From: Rhiannon Lloyd
Sent: 11 May 2026 15:19
To: Planning.Responses
Subject: Fw: Re: FP/31/26/HH - 9 Roundle Square
Attachments: 9, Roundle Square Planning Amendment Sheet 5a of 6 .pdf; 9, Roundle Square Planning Amendment Sheet 6a of 6 .pdf

From: BRYAN BUTCHER [REDACTED]
Sent: Monday, May 11, 2026 14:08
To: Rhiannon Lloyd <Rhiannon.Lloyd@arun.gov.uk>
Subject: Re: Re: FP/31/26/HH - 9 Roundle Square

Sheet 4 of 5

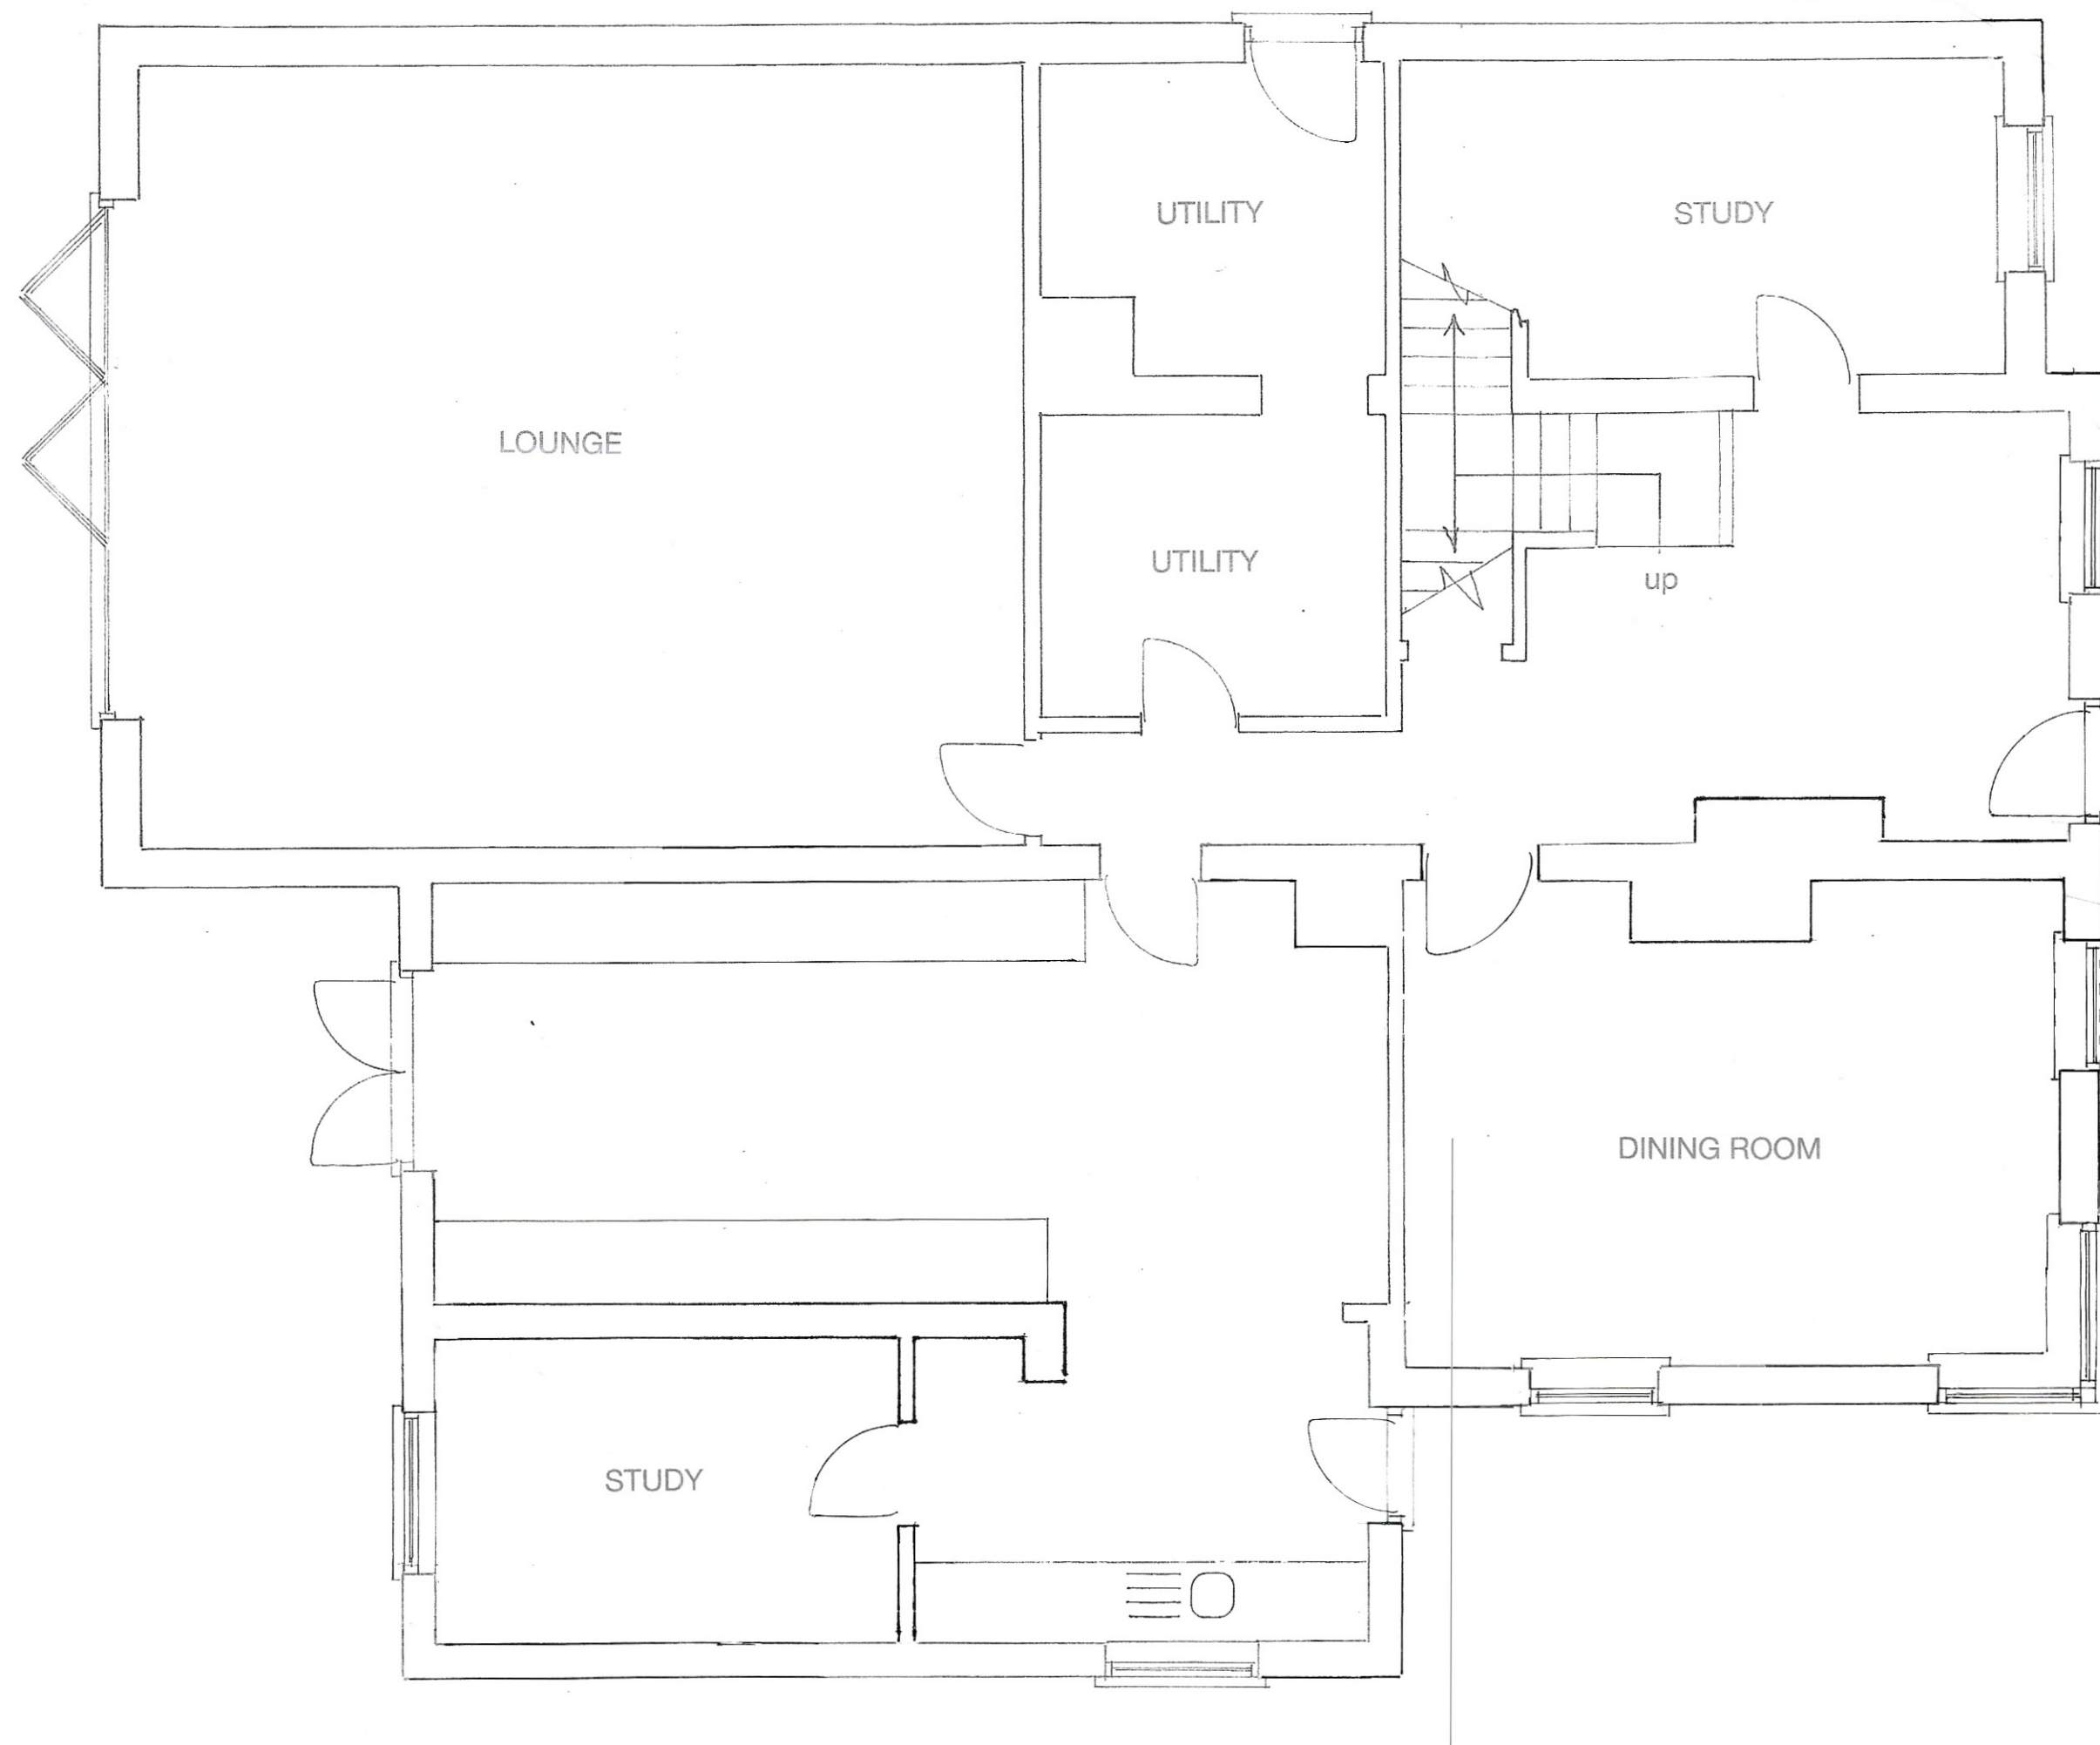
I also notice that the existing plans appear to be incorrect. The floor plans, elevations and roof plan do not show the single storey porch as existing. The roof plan does not accurately show the existing crown roof either.

Please could the plans be updated to accurately reflect the existing situation.
